Appeal Decision

Appeal Ref: APP/R4408/D/24/3355202

6 Saffron Court, Wombwell, Barnsley S73 0AP

- The appeal is made under section 78 of the Town and Country Planning Act 1990 (as amended) against a refusal to grant planning permission.
 - The appeal is made by Mr M Perkins against the decision of Barnsley Metropolitan Borough Council.
 - The application Ref is 2024/0724.
 - The development proposed is for an attached garage.
-

**PROPOSED ATTACHED
GARAGE
6 SAFFRON COURT
WOMBWELL S73 OAP
SCALE 1:100, DRWG No P1**

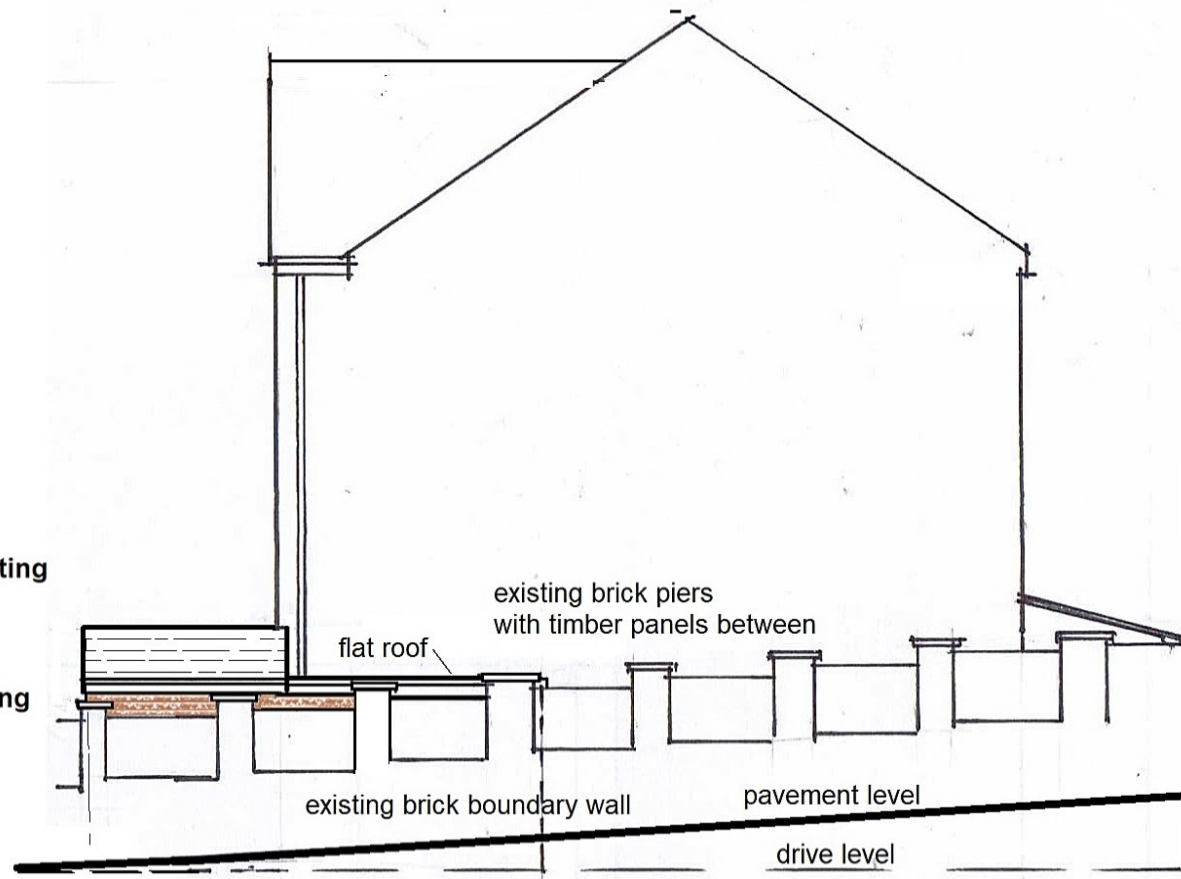
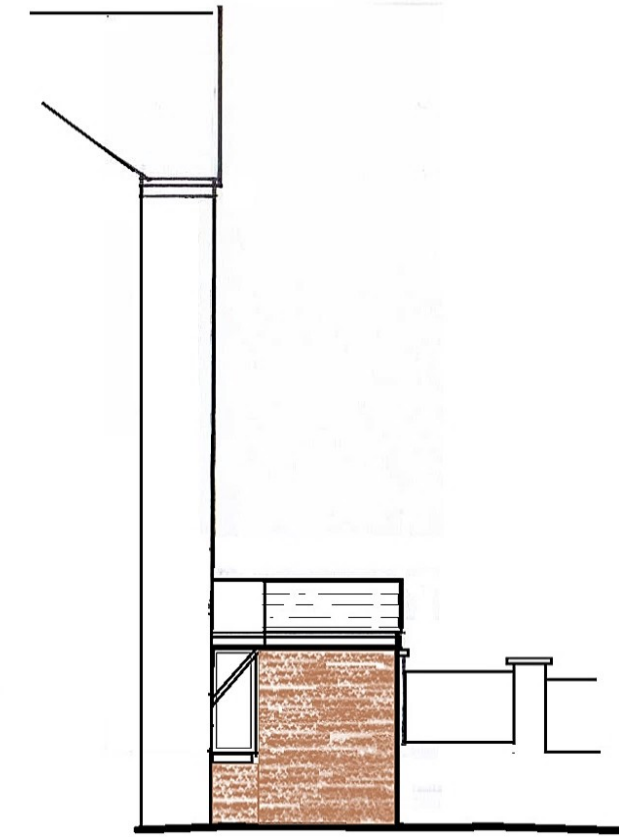
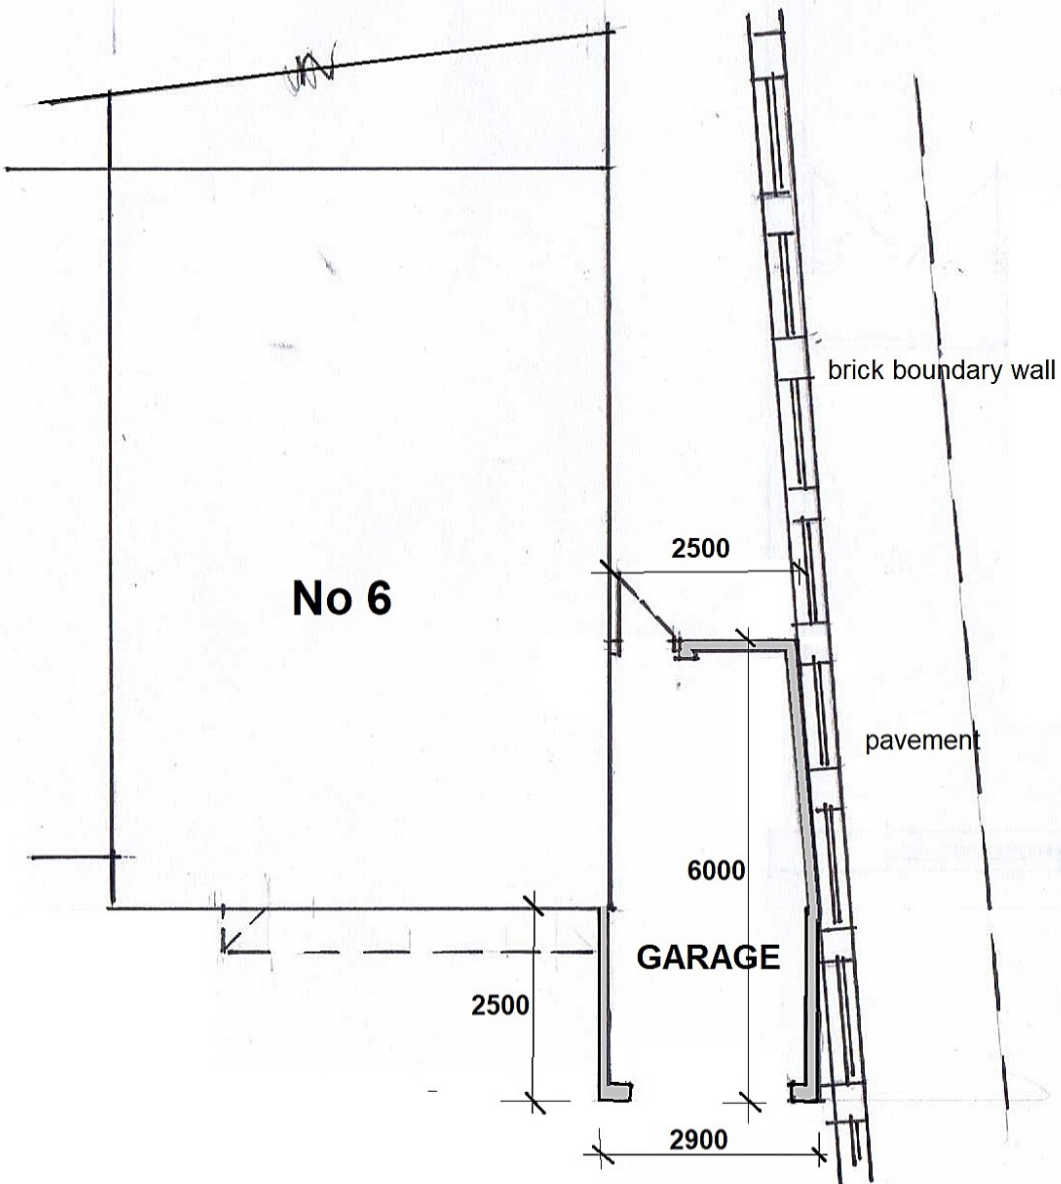
5. The proposal would introduce a small single storey garage to the front and side of the property. Although the extension would be mainly constructed using matching materials, its footprint and roofline would be contrived given the small space available. Combining this with its substantial forward projection from the terrace, the proposal would be an awkward addition to the otherwise consistent pattern that is experienced on Saffron Court.

6. The proposal would therefore cause harm to the character and appearance of the area and thus be contrary to Policy D1 of the Barnsley Local Plan 2019 which is concerned with development reinforcing local character amongst other things.
